Ribble Valley Borough Council
Housing & Development Control

Application no: **3/2021/0858**

Address: **Fishes And Peggy Hill Farm Henthorn Road Clitheroe BB7 3BY**

Proposal: **Proposed erection of 6 lodges with associated infrastructure.**

Proposed Site Plan

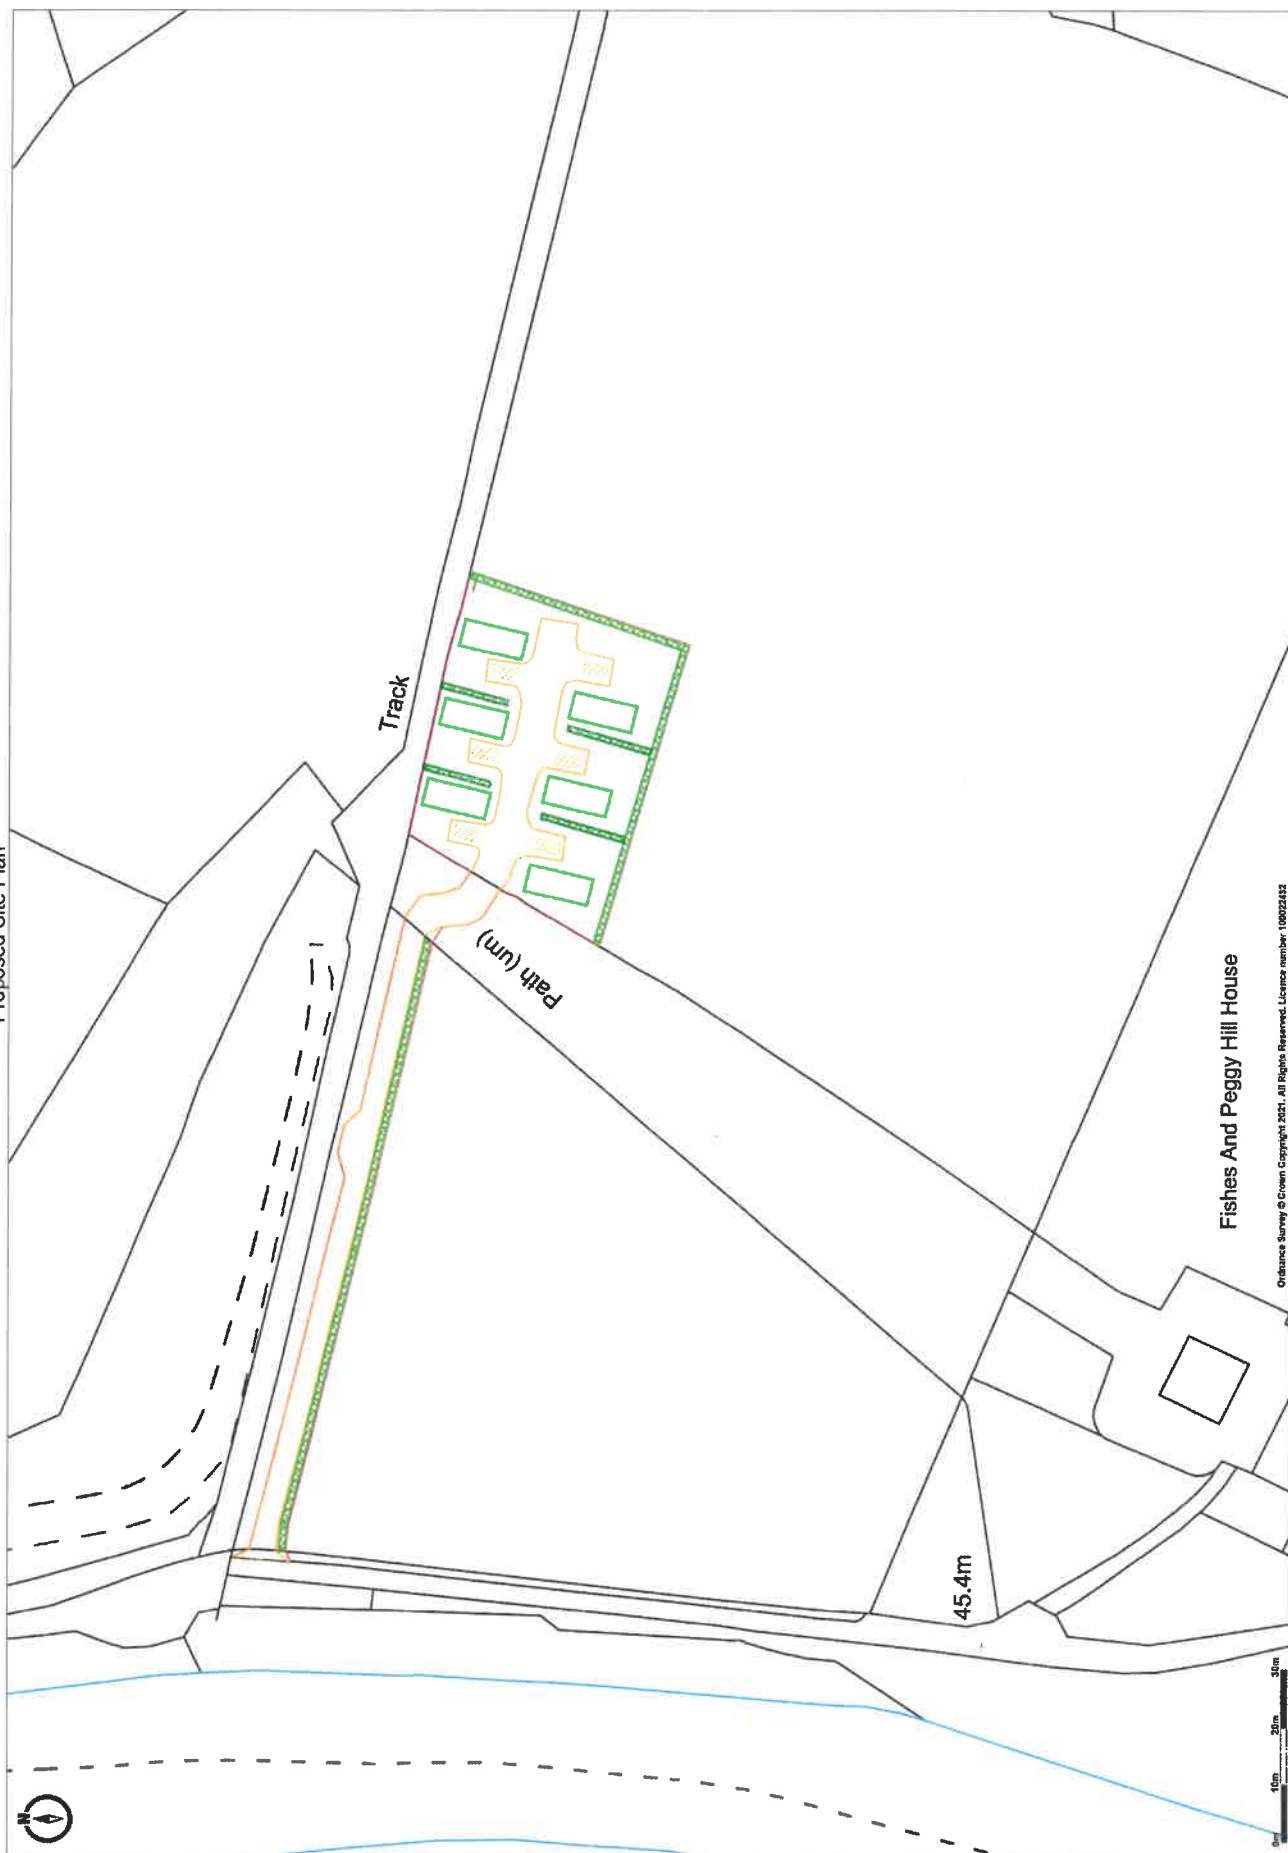
The LHA have reviewed Promap drawing titled "Site Layout Plan" and understands that the proposal will be served by a new access track leading into the site from Henthorn Road.

The LHA have reviewed the track and have no comments to make with the site being directly off an unadopted, private road. That being said the access arrangements do comply with the LHAs guidance.

The LHA have reviewed Promap drawing titled "Site Layout Plan" and are satisfied that the parking arrangements complies with the parking standards as defined in the Joint Lancashire Structure Plan with each lodge having access to one car parking space.

2. No part of the development hereby permitted shall be occupied until such time as the access arrangements shown on Promap drawing titled "Site Layout Plan" have been implemented in full.

4.The development hereby permitted shall not be occupied until such time as the parking and turning facilities have been implemented in accordance with Promap drawing titled "Site Layout Plan". Thereafter the onsite parking provision shall be so maintained in perpetuity.
